Project: The Vinery, Poling.

Please accept this letter with respect to the amendments to the landscape scheme for the approved planning application at The Vinery, Poling.

drawing title: **Planting Plan Segment 1**

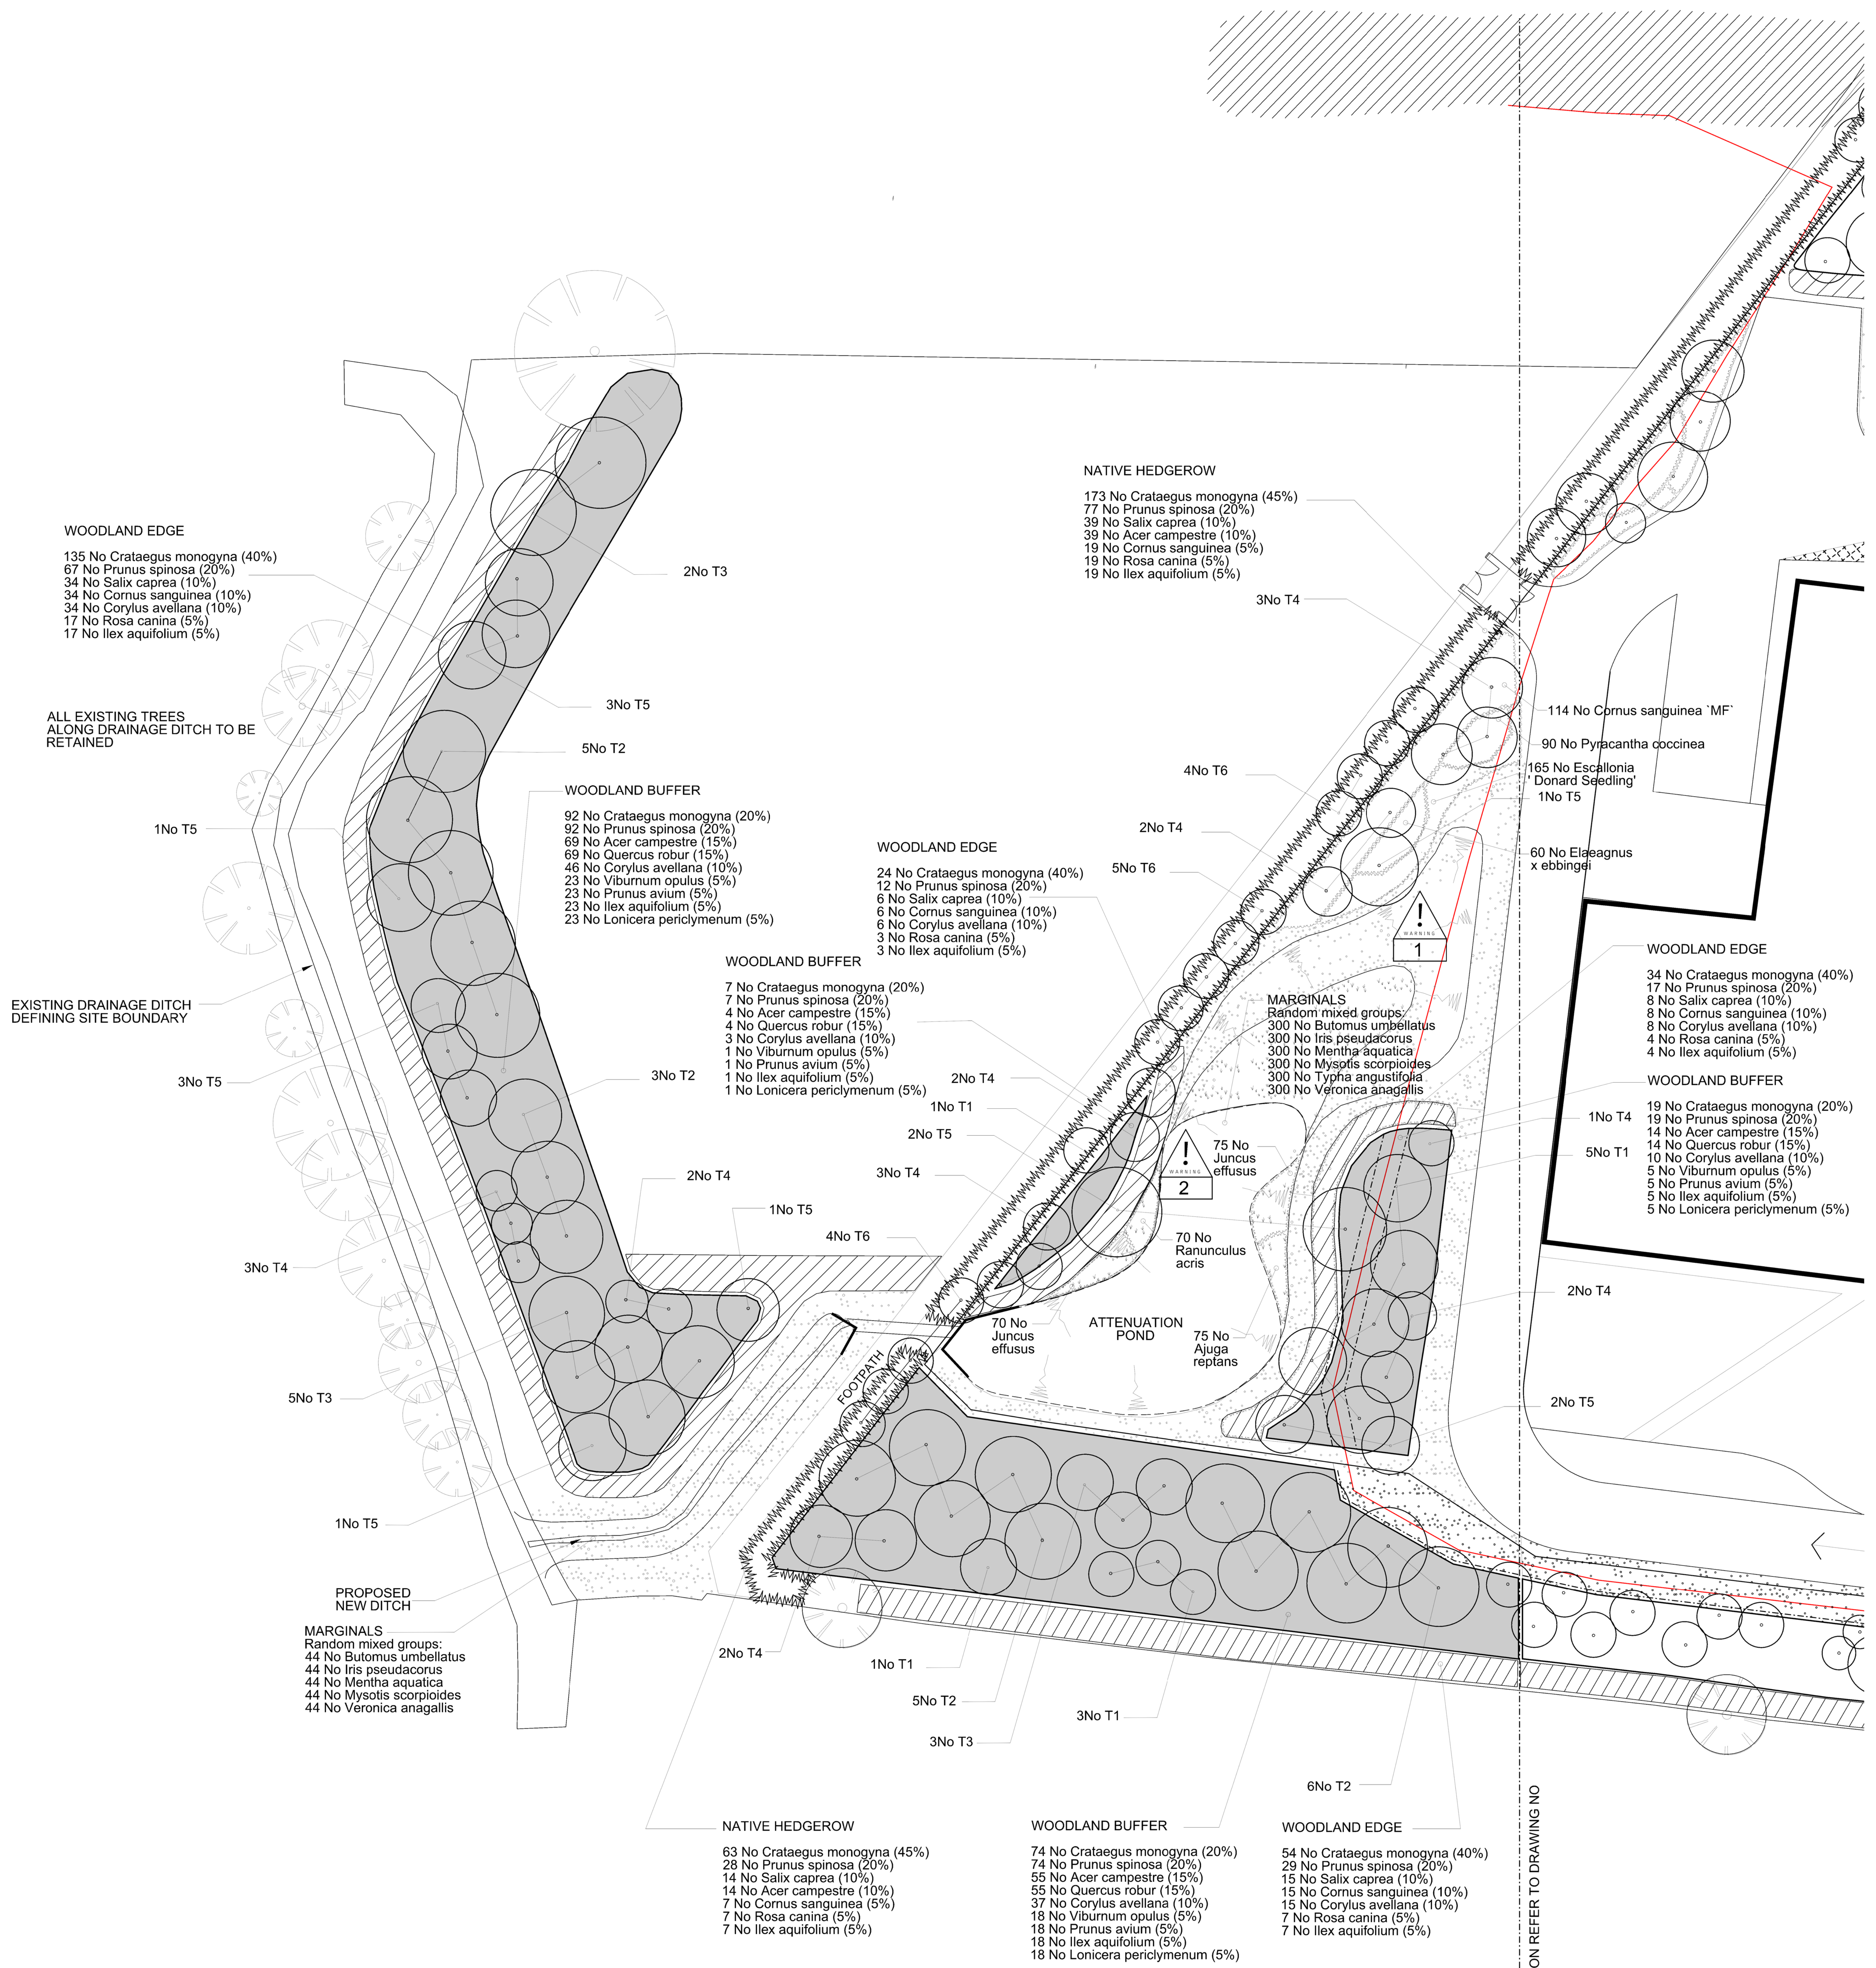
The landscape scheme has been amended to incorporate the route of a HV cable cutting through the site. This has required minor amendments to the planting plans and their schedules.

1. Planting zones have been adjusted to suit the utilities corridor.
2. Larger tree species have been moved so as not to have conflict with the utilities corridor.
3. The location of the sub-station is now included on the planting plans.
